KITTITAS COUNTY COMMUNITY DEVELOPMENT SERVICES

Martens Enterprises, LLC
PO Box 458
Cle Elum, WA 98922
RE: Incomplete Application

Kittitas County Community Development Services accepted your application for the proposed Marion Meadows Estates PUD on December 22, 2016. The application materials submitted were for a Planned Unit Development Rezone (PUD), a Long Plat Application, an Administrative Conditional Use Permit (CUP) application, and a Development Agreement (D.A.).

Letter of Incomplete Application –Applicants Response

Exh. MM #1

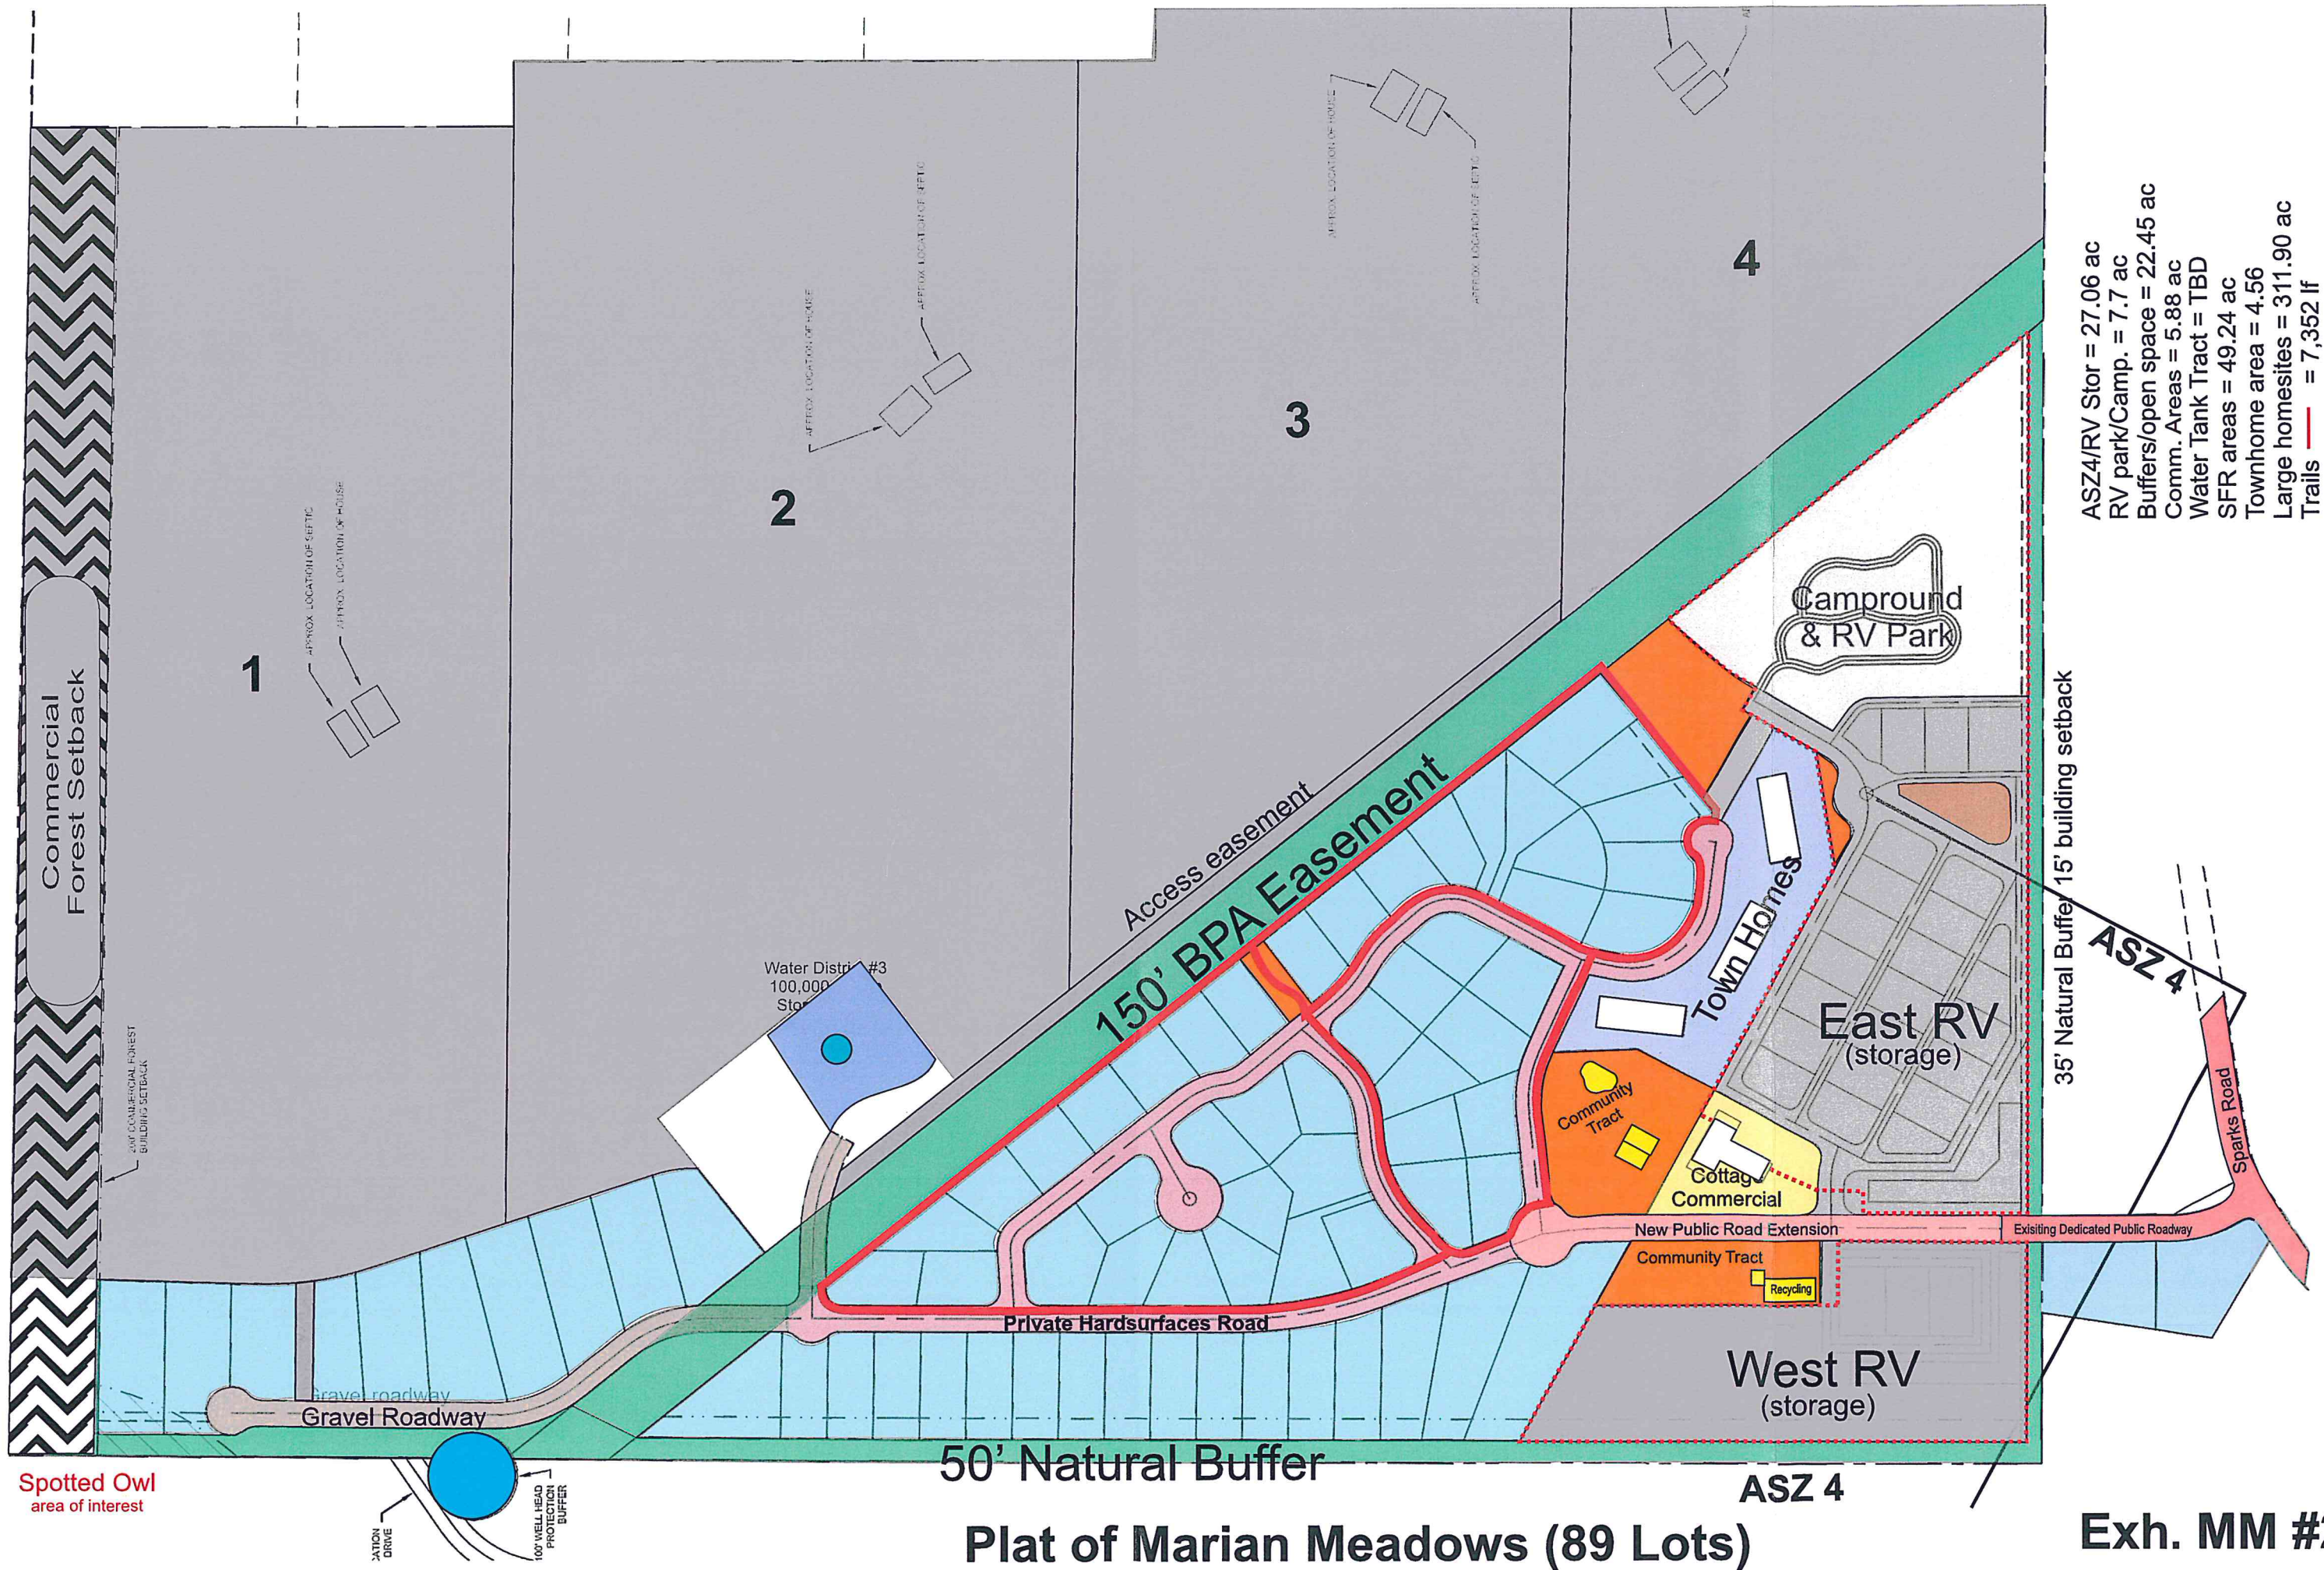
- f) Include utility easements (min. 10 ft.) on each proposed lot per KCC 16.12.110. See Encompass Engr.
- g) Clearly identify primary access, secondary access, and emergency vehicle only (EVO) access. See Exh. MM#2

JOB NO. 16091
 DATE: MARCH 2017
 SCALE: 1"=200'
 DESIGNED: GC
 DRAWN: SOC/IGC
 CHECKED: C.J.H. WAKY
 APPROVED: C.J.H.
 SHEET **P2.0**

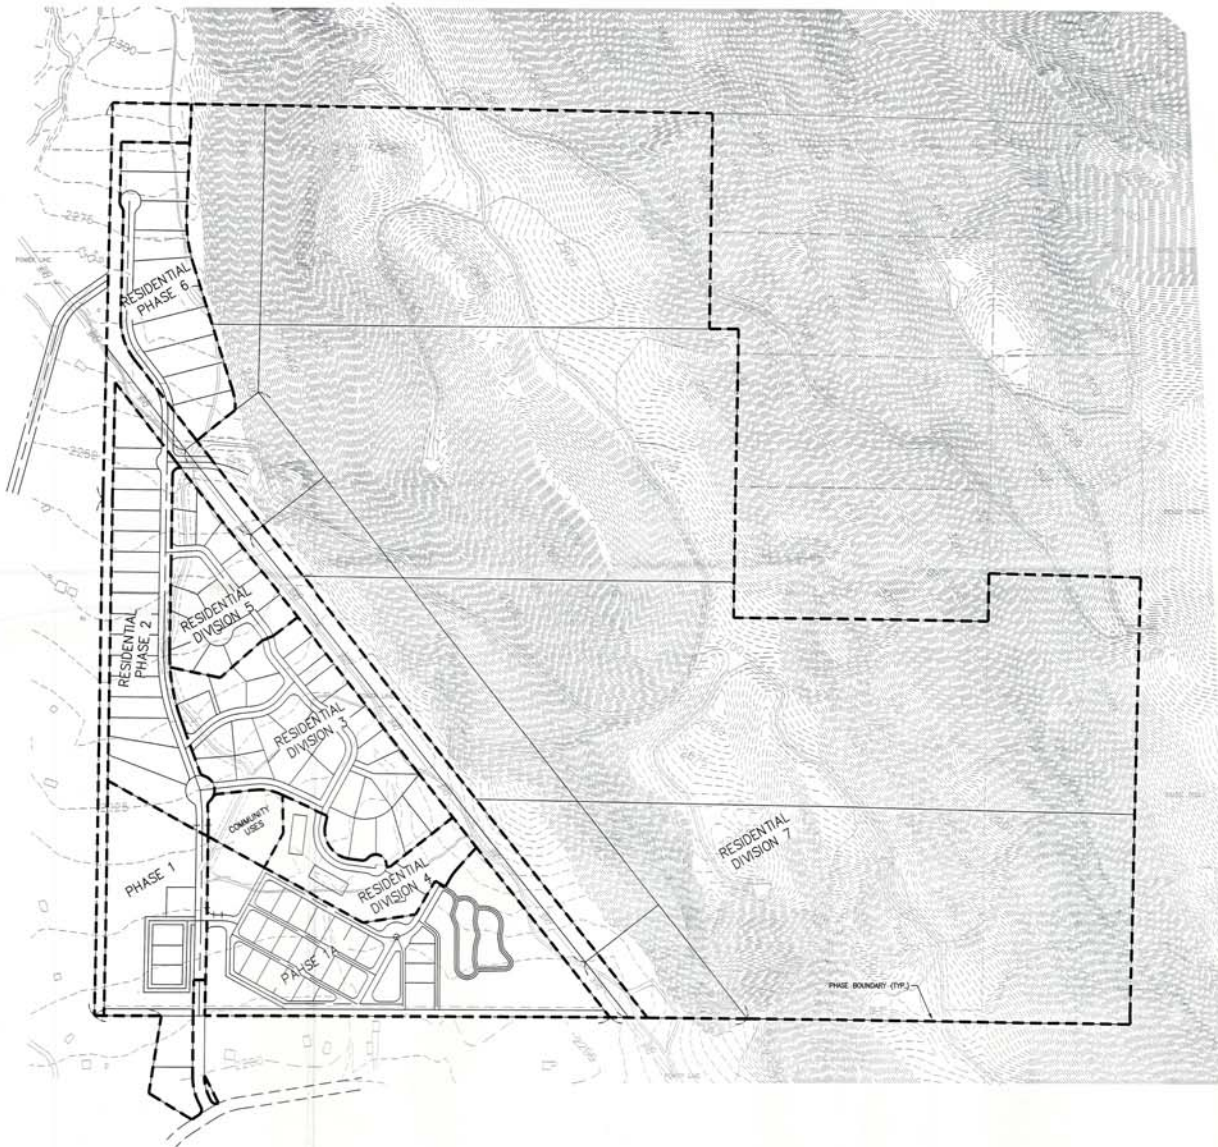
- e) Provide a table on Sheet P2.0 with total acreage and number of lots per phase, including identification of tracts within each phase (label, purpose, area) per KCC 16.12.060(3). Label lots sequentially within each phase/division. See Encompass Engr.

MARIAN MEADOWS ESTATES PUD - SP-15-00010
EXISTING CONDITIONS PLAN
 A PTN OF SEC. 1 & A PTN OF SEC. 12, T. 20 N., R. 13 E., W.M.
 KITTITAS COUNTY, WASHINGTON

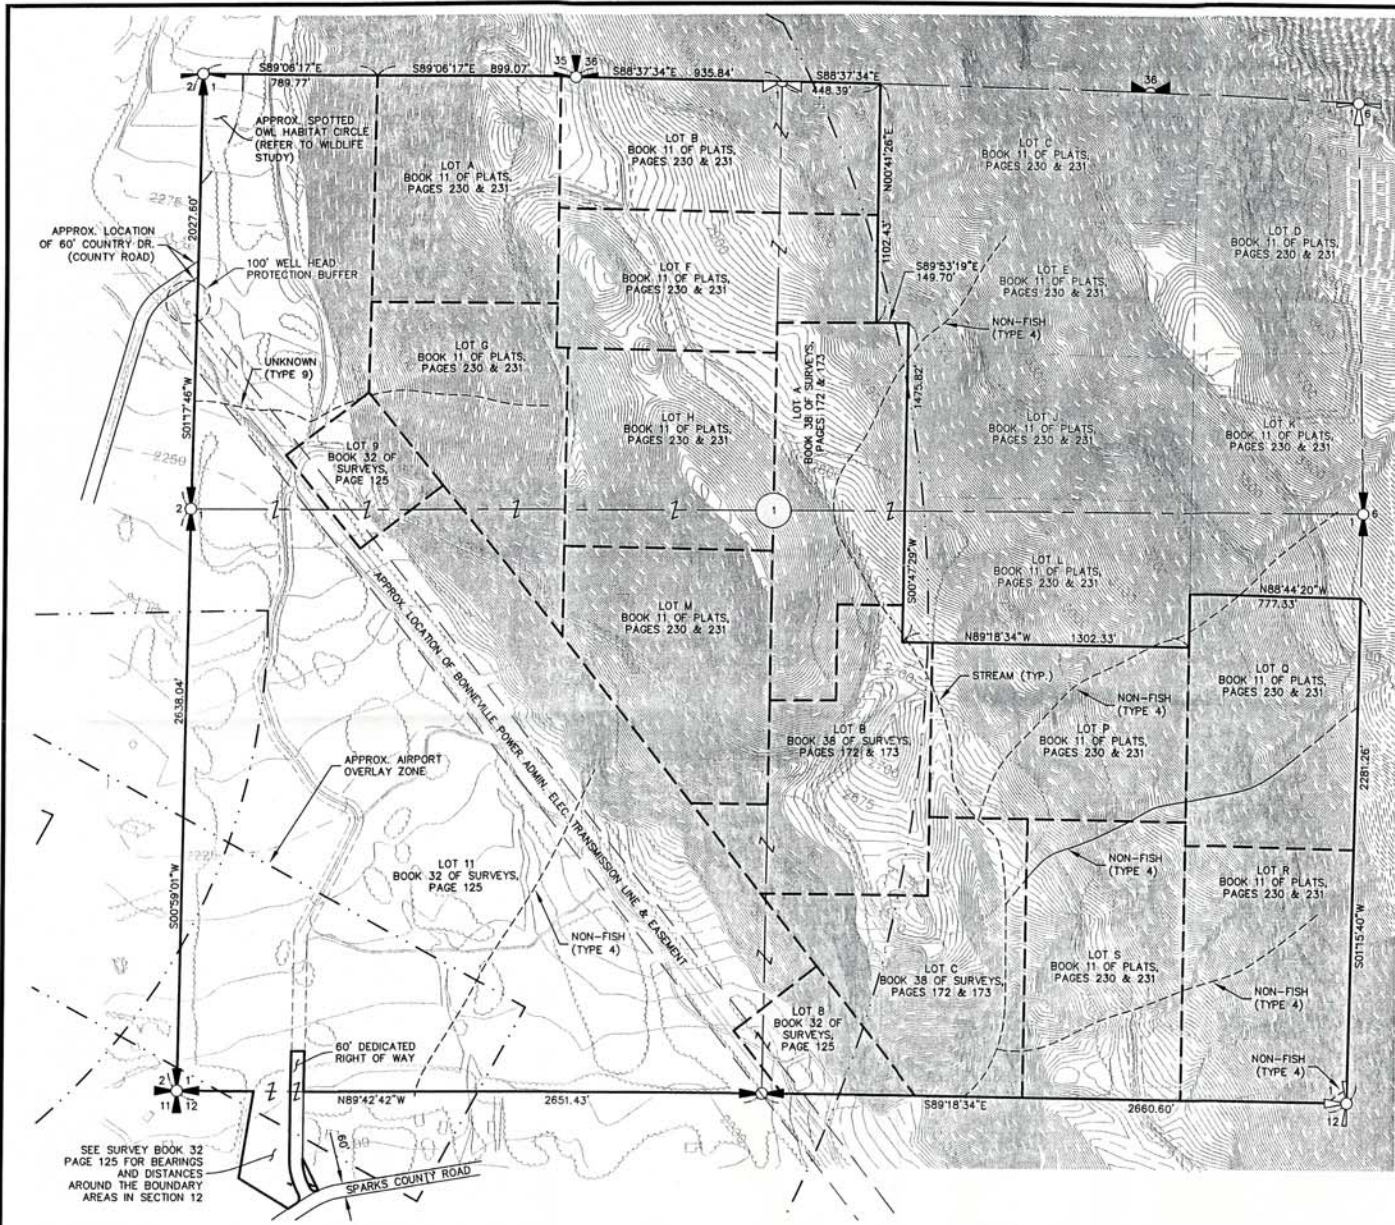
- III. Plan Requirements:
 - a) Please submit an Existing Conditions Plan per KCC 16.12.030 and 17.36.030(4)(a). See Encompass Engr.
 - b) Submit a Landscaping Plan per KCC 17.36.030(5). See engineering plan P3 and Exhibit MM#2 for designated open space buffers and community tracts. Identified open space buffers are earmarked for retention of native vegetation with limited development encroachment. Buffer management will include provisions for vegetation height control consistent with airport operations. This is addressed within the DA under question #11.
